17 December 2018

Samuel Gilbert Public School, Castle Hill

PRE-LODGEMENT MEETING NOTES

APPLICANT: Andrew Minto – Minto Planning Services
CONTACT: planning@mintoplanning.com.au or 9875-4788
PROPERTY: 1 Ridgecrop Drive, Castle Hill (Lot 1 DP 719671)
ZONING: R2 Low Density Residential
SITE AREA: 82,880m²
SUBJECT: Alteration and additions to the existing Samuel Gilbert Public School

Figure 3 Reduced height of Building N

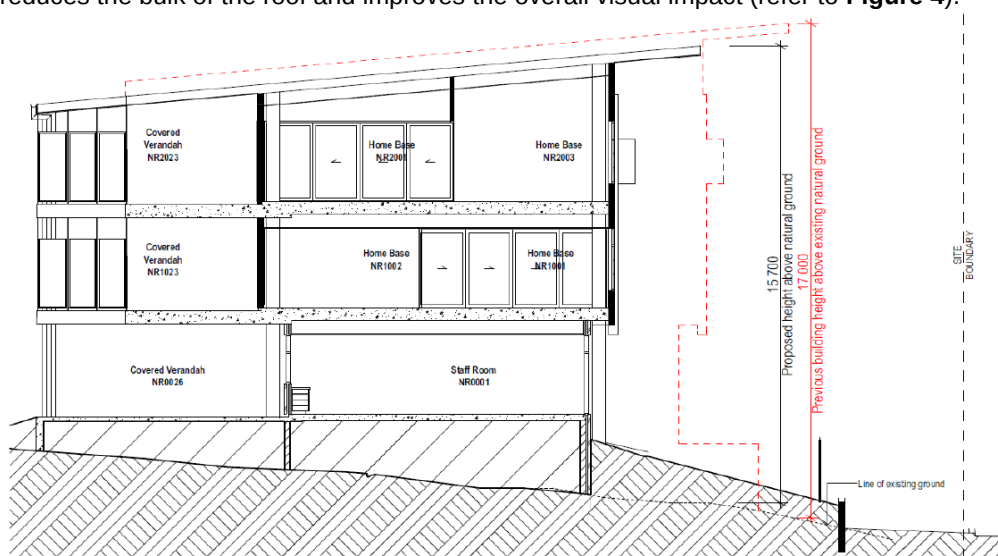
Buildings N and P will have a proposed height of 17m, representing a significant departure from the maximum 9m height limit. The substantial height breach will be most evident from Ridgecrop Drive where a number of established canopy trees are proposed for removal. The proposal is considered to fail Principle 1 of Schedule 4 Schools – design quality principles of SEPP (Educational Establishments and Child Care Facilities) 2017. The removal of these canopy trees along with a reduced setback to Ridgecrop Drive limits opportunity for the potential for replanting, in turn, the proposal is unable to ensure landscaping is integrated into the design of the school.

Figure 8 Additional kiss and drop zones (shown in red)

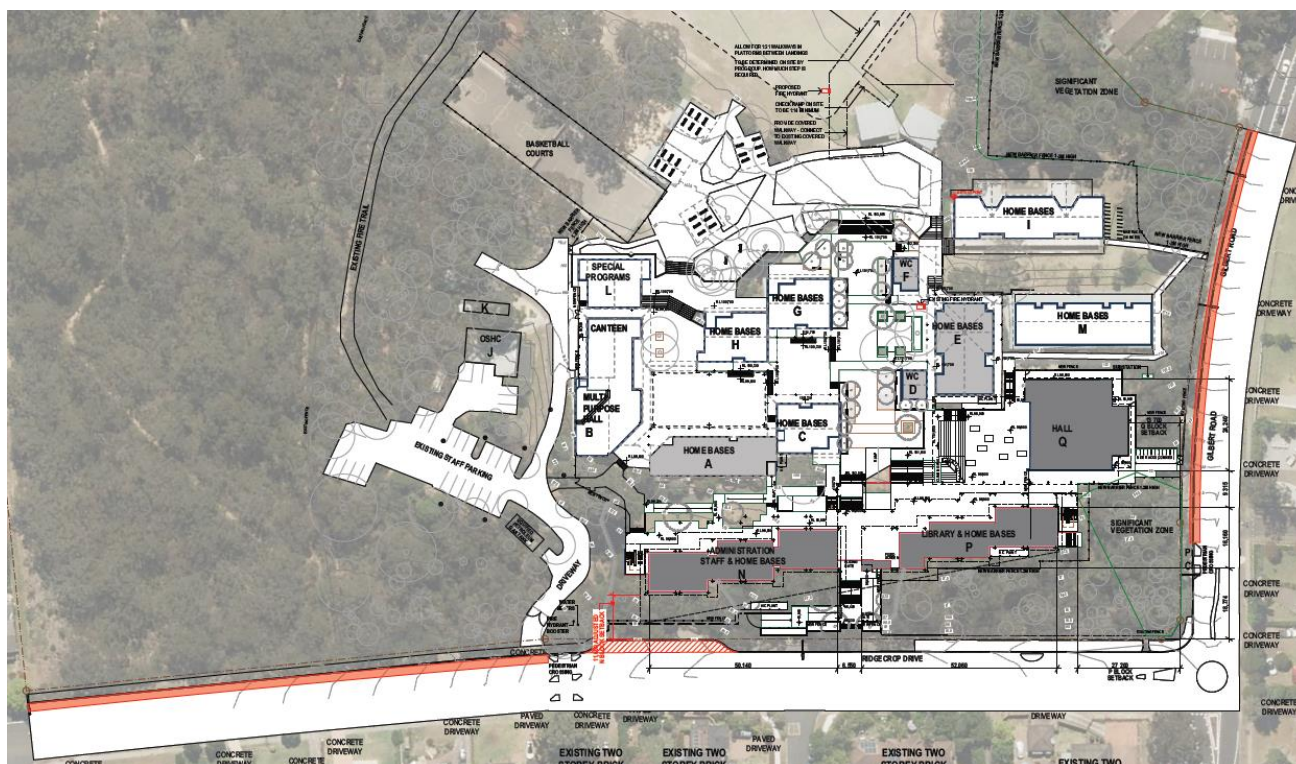
It is understood that the 'Kiss and Drop' indent area located along Ridge has recently been 'shutdown' due to traffic and congestion concerns. It is suggested that a 'Kiss and Drop' area be provided within the confines of the school grounds to help address this issue.
